December 17, 2025

**RE: Lindo Mexico Restaurant
3937 Coors Blvd NW
Grading and Drainage Plan
Engineer's Stamp Date: 12/5/2025
Hydrology File: G11D067H
Case # HYDR-2025-00436**

Based upon the information provided in your submittal received 12/05/2025, the Grading & Drainage Plans **are not** approved for Building Permit. The following comments need to be addressed for approval of the above referenced project:

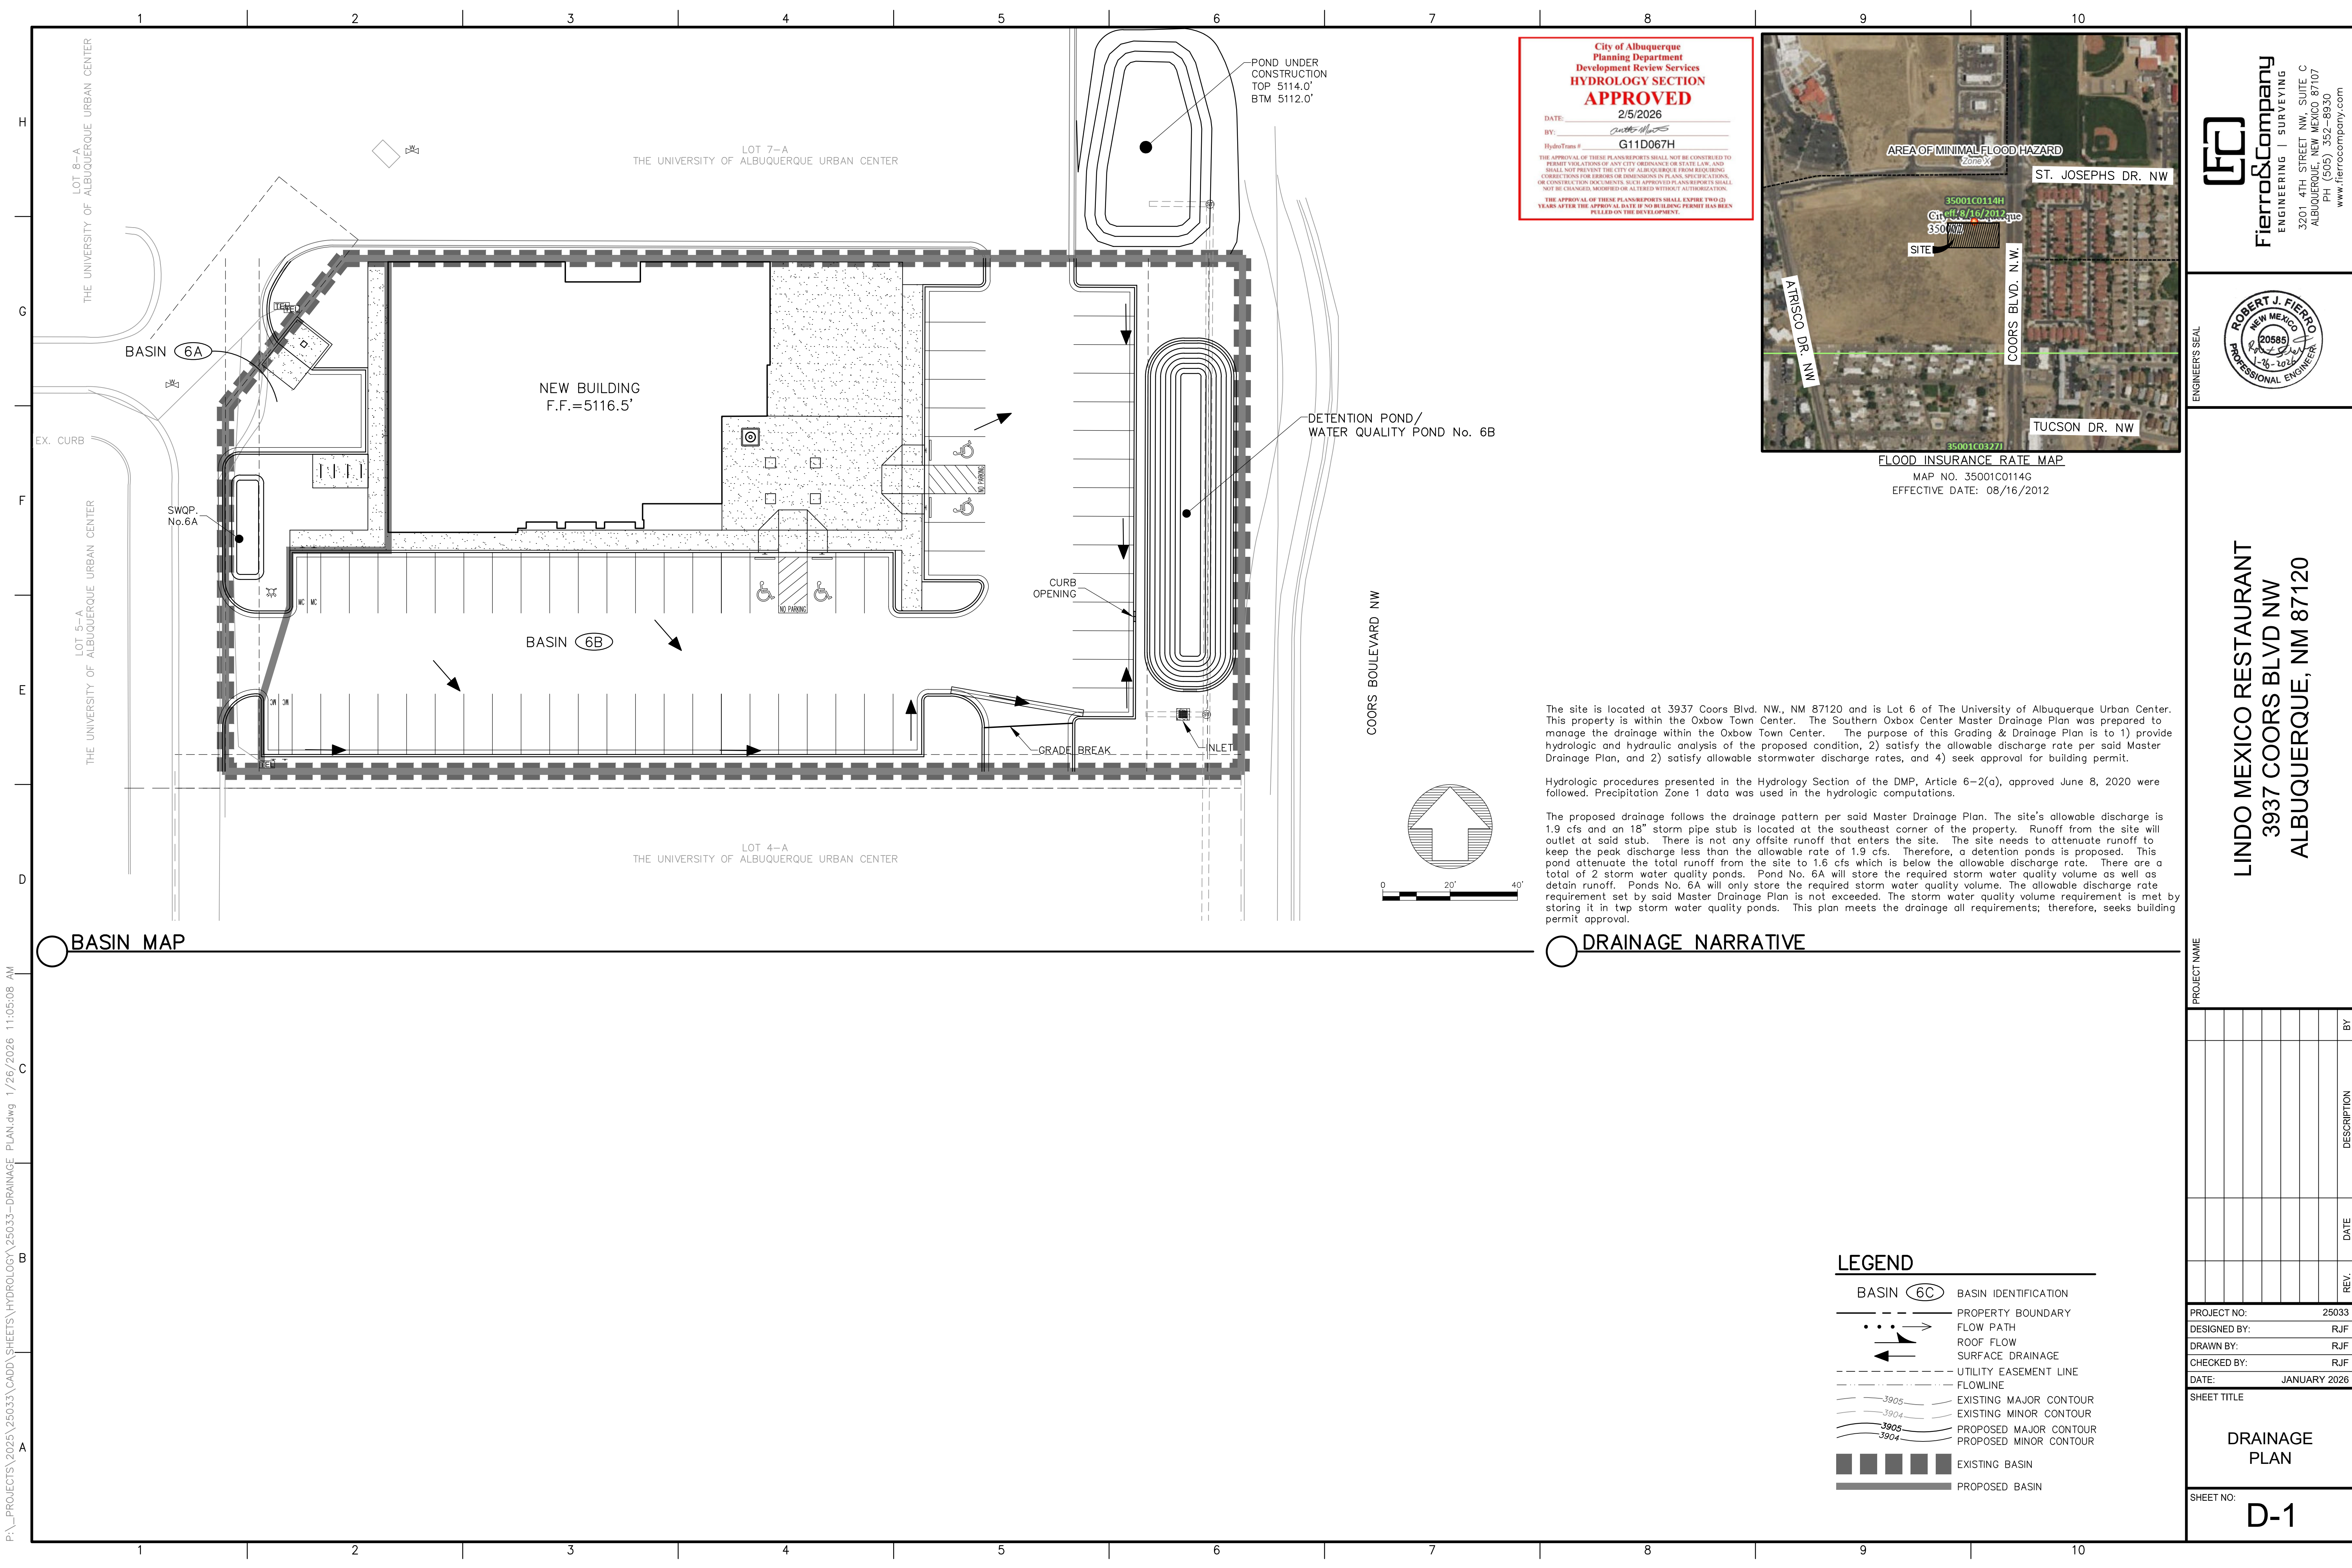
1. For trash enclosures serving food service developments, trash enclosures must demonstrate control of liquids from dumpster areas per DPM by containing runoff from the dumpster area, preventing outside drainage from entering the dumpster area, and discharging to the sanitary sewer. Please show an inlet in the middle and label. "Inlet to be connected to the sanitary sewer. See Utility Plan."
2. Please provide a table showing the Existing and Proposed Land Treatment Types (A, B, C, D) with percentages and areas.
